About the application

Application number: 2022/91635	
What is the application for?:	The extension projects 3.3m beyond the rear wall of the original dwellinghouse.
Address of the site or building:	28, Lindley Avenue, Birchencliffe, Huddersfield, HD3 3QU
Postcode:	HD3 3QU

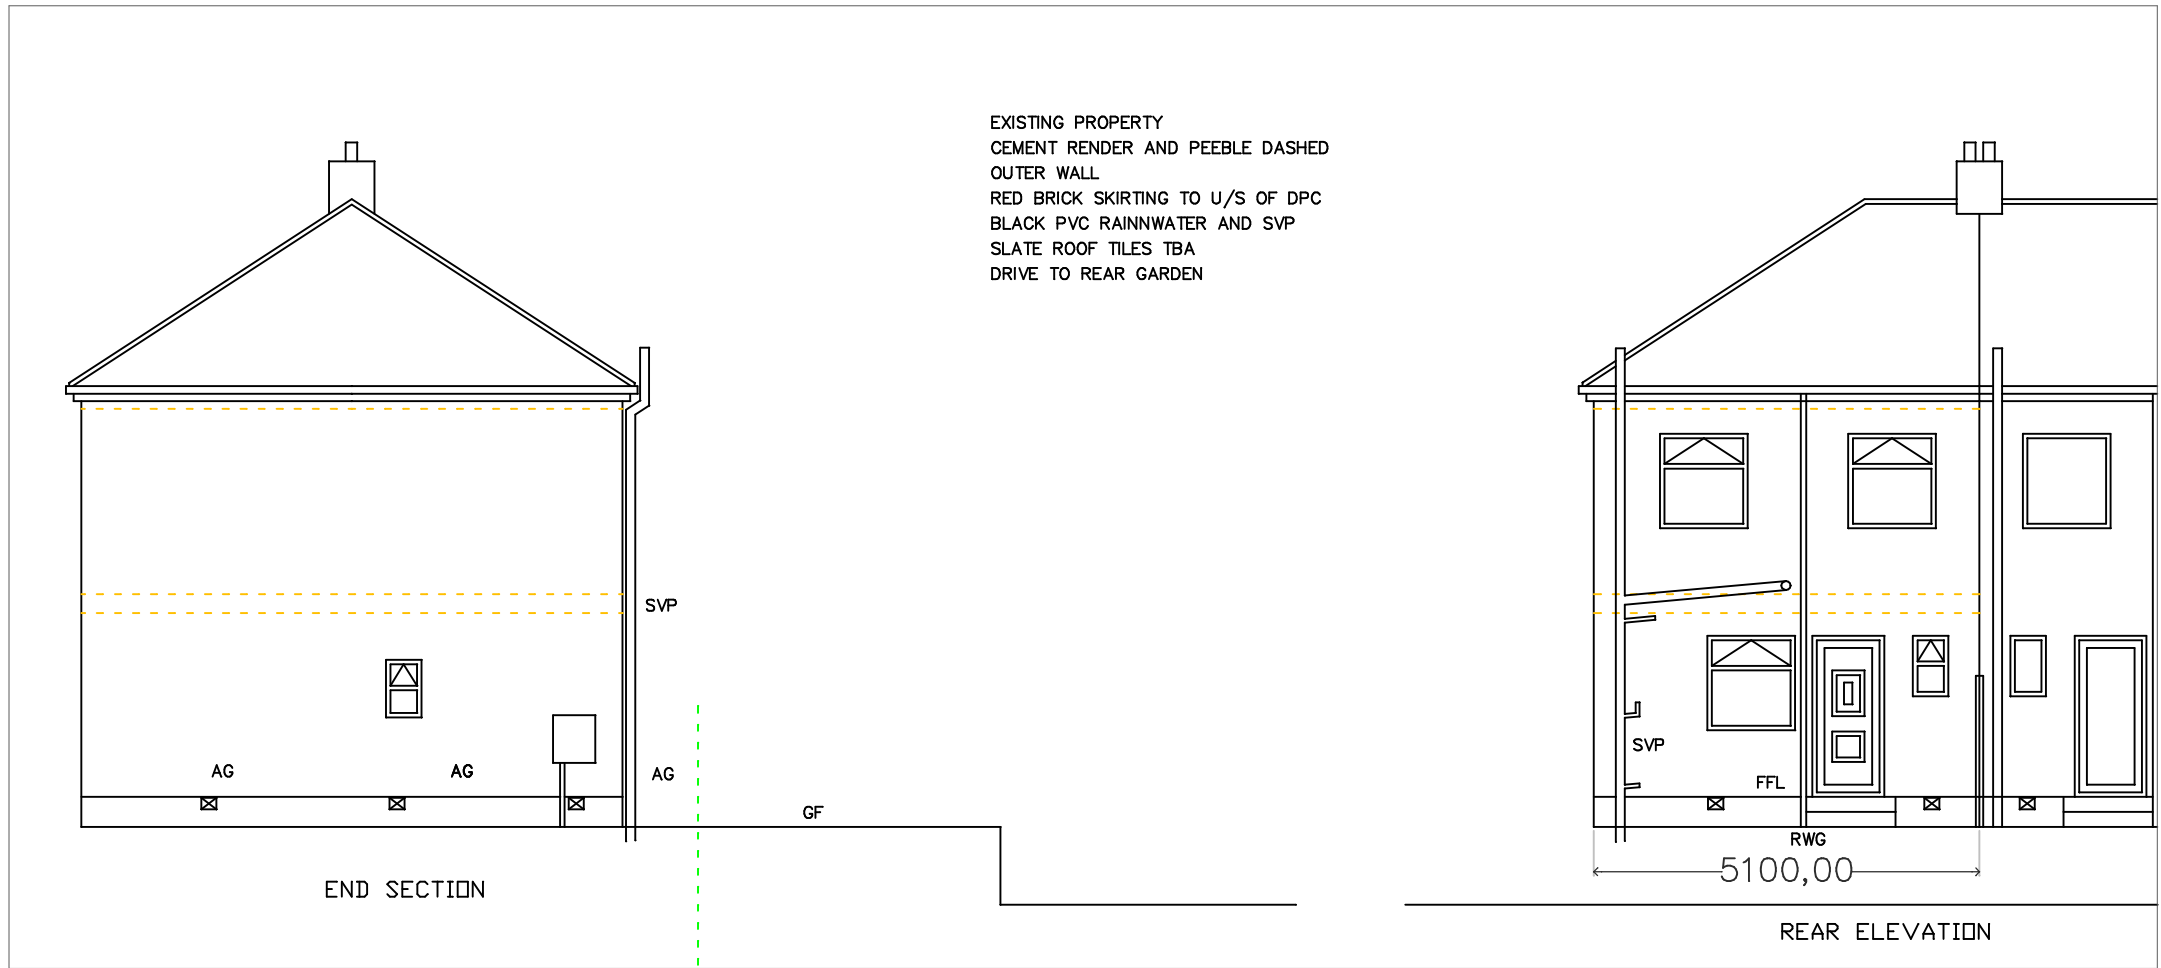
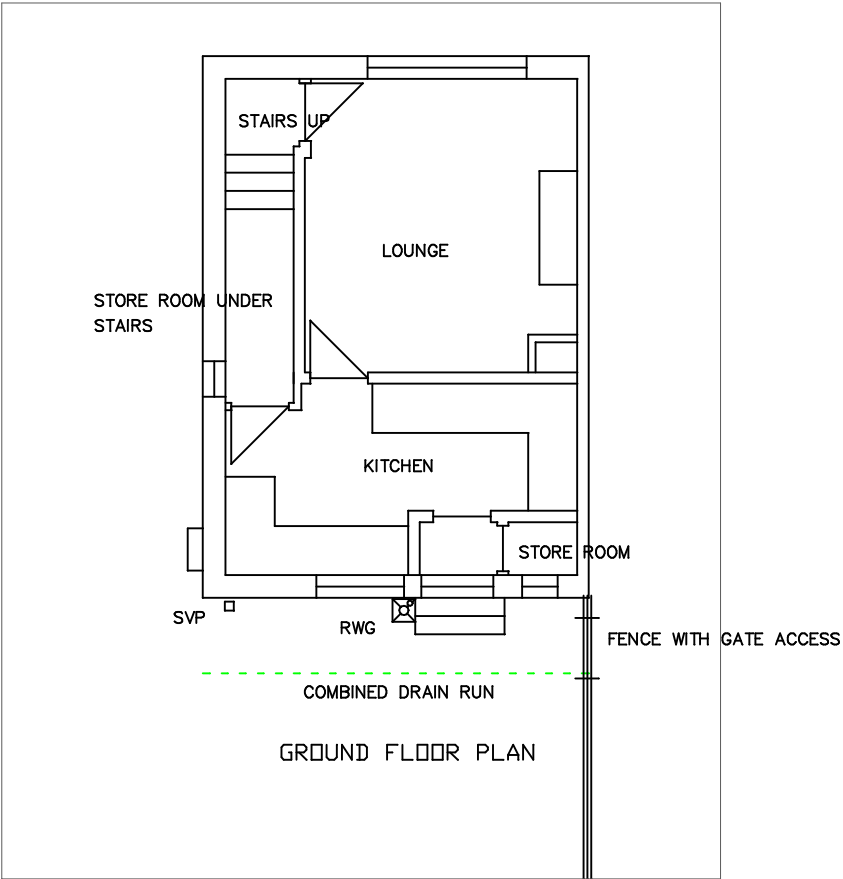
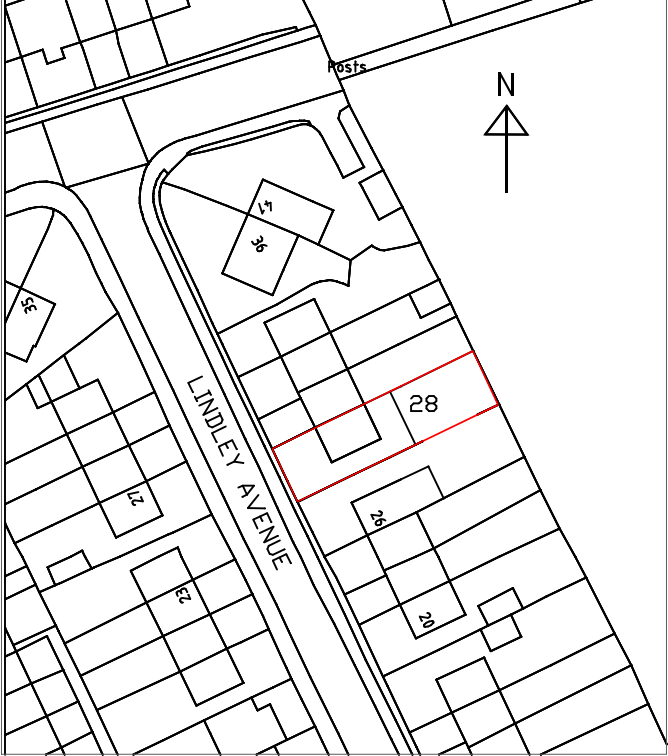
Type of comment: An objection	
Do you wish your comments to be published on the website anonymously?	No
I have consulted a builder about the proposed plans. He attempted to contact the architect to discuss my concerns with no response so therefore I have to object to the plans due to the following reasons: 1. Right of Access The proposal to move the gate and therefore my access is not viable on my property. I have an area of paving, finished with a wall, and my paved area does not extend far enough to accommodate access through the proposed new gate location as there is a significant drop after the wall therefore the area is not flat or safe. I have landscaped my garden at a significant cost and the fence and gate which is proposed to be moved is my fence and gate and is on my land. I am unwilling to incur further costs to make amends to my garden to accommodate the proposed new access. 2. Risk to my property The foundations level shown on the drawings are 2 metres deep which raises concerns that when the builders underpin my neighbours property, mine is at risk of subsiding because the proposed extension is up to the boundary of my property. There is no plans to underpin or safeguard my property so this is a significant concern.
